Date: 25/06/2025

File No. ABP 321238-24

SID - 110kV Electricity Substation, approximately 7.5km of Underground Electricity Line

Drawing Title:
**FIGURE 6.2: SITE LAYOUT PLAN 2 OF 2
(1:500)**

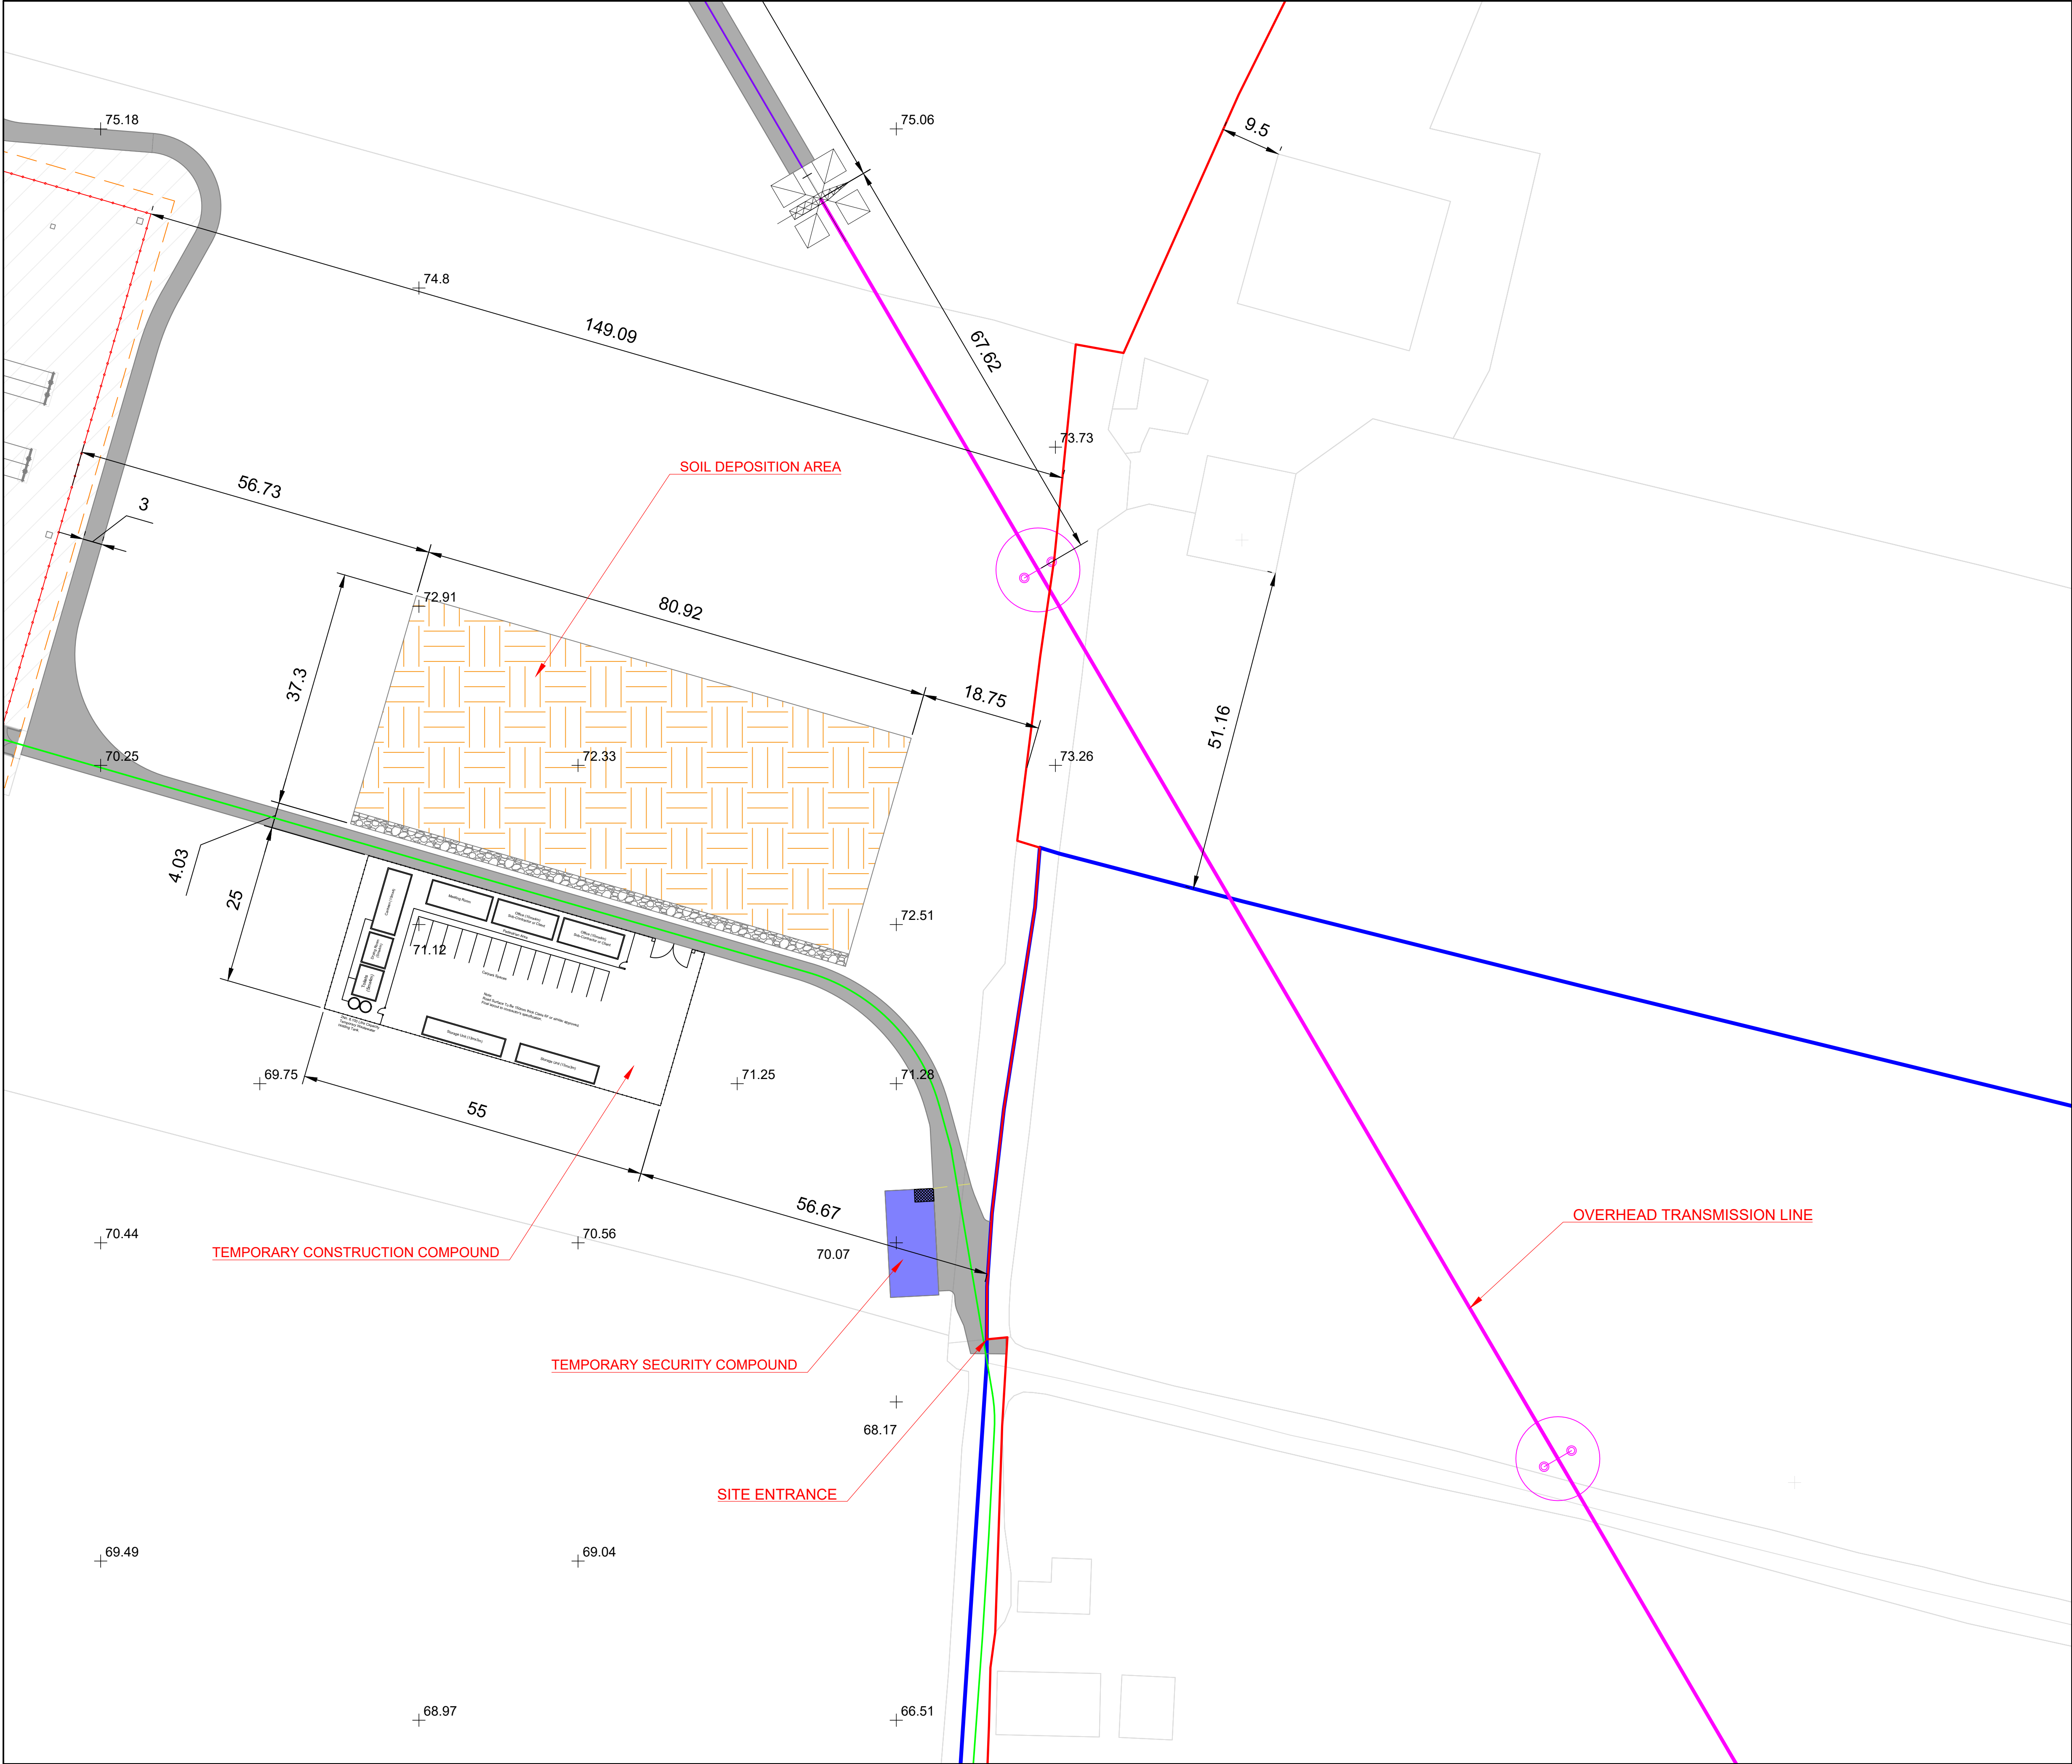
- Effectiveness of mitigation measures proposed and amended by conditions recommended for application where The Board are minded to approve the proposal.
- Application of planning conditions to:
 - Extend the requirement for construction phase noise barriers at the substation site to include the western boundary.
 - Restrict construction of the cable route and HDD crossing of the River Cross to the summer for the purpose of mitigating potential impacts on QI winter populations of birds.
